From: Amanda Scholes on behalf of Planning.Responses
Sent: 17 November 2020 10:42
To: Planning Scanning
Subject: FW: Y/94/20/DOC, kiosk &

Subject: Y/94/20/DOC, kiosk &

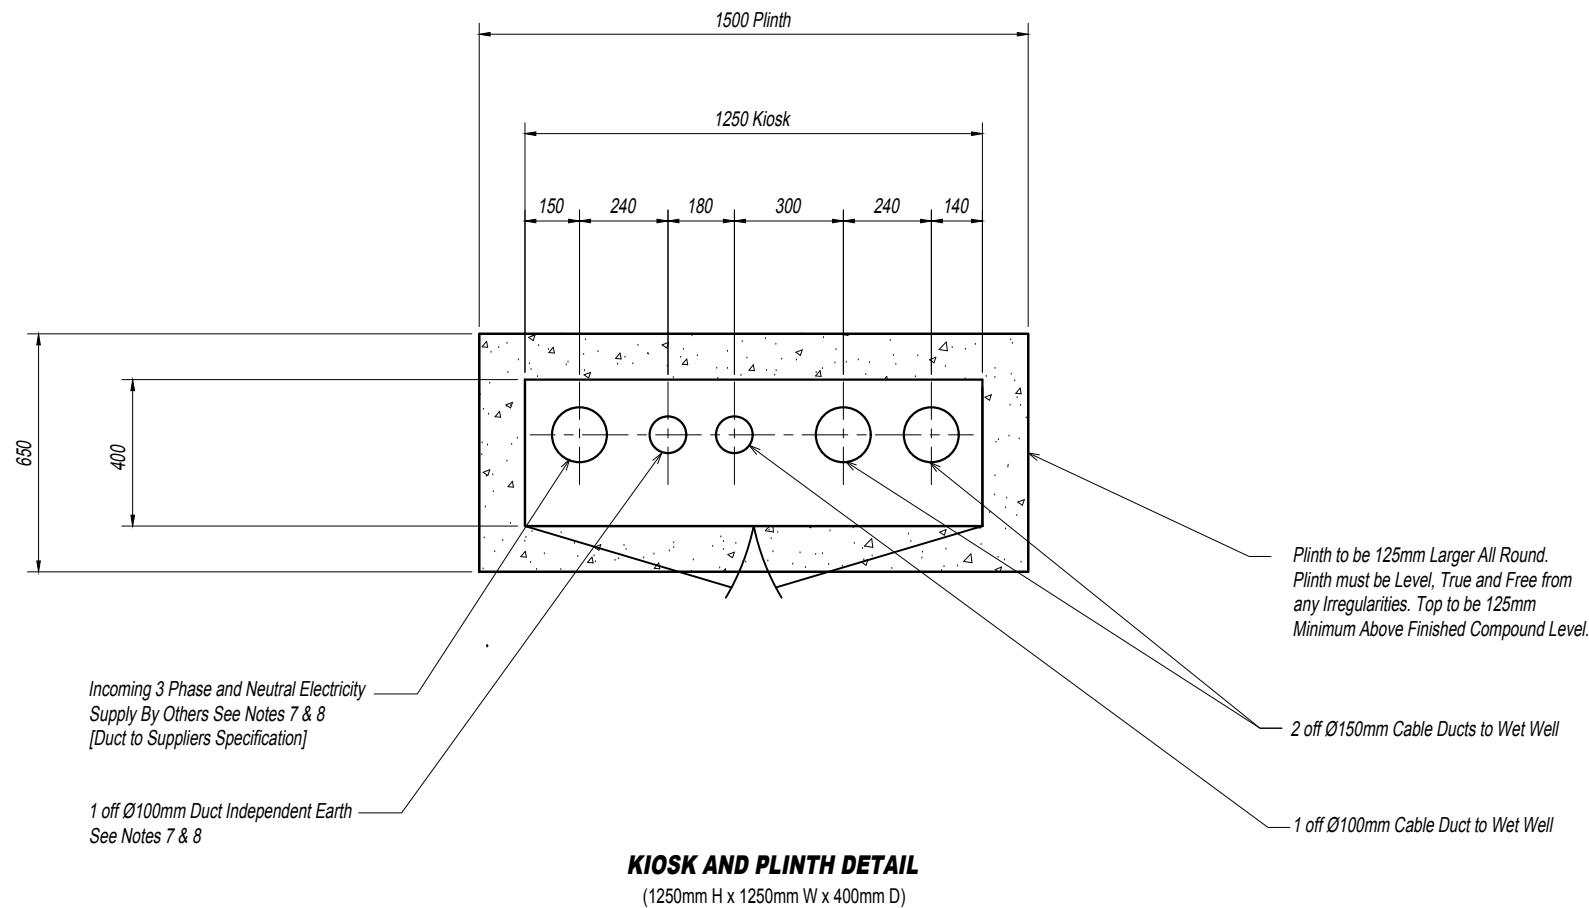
Is it the kiosk alone which will be over the ground?
No fence?

Are you providing us with elevations.

Correct
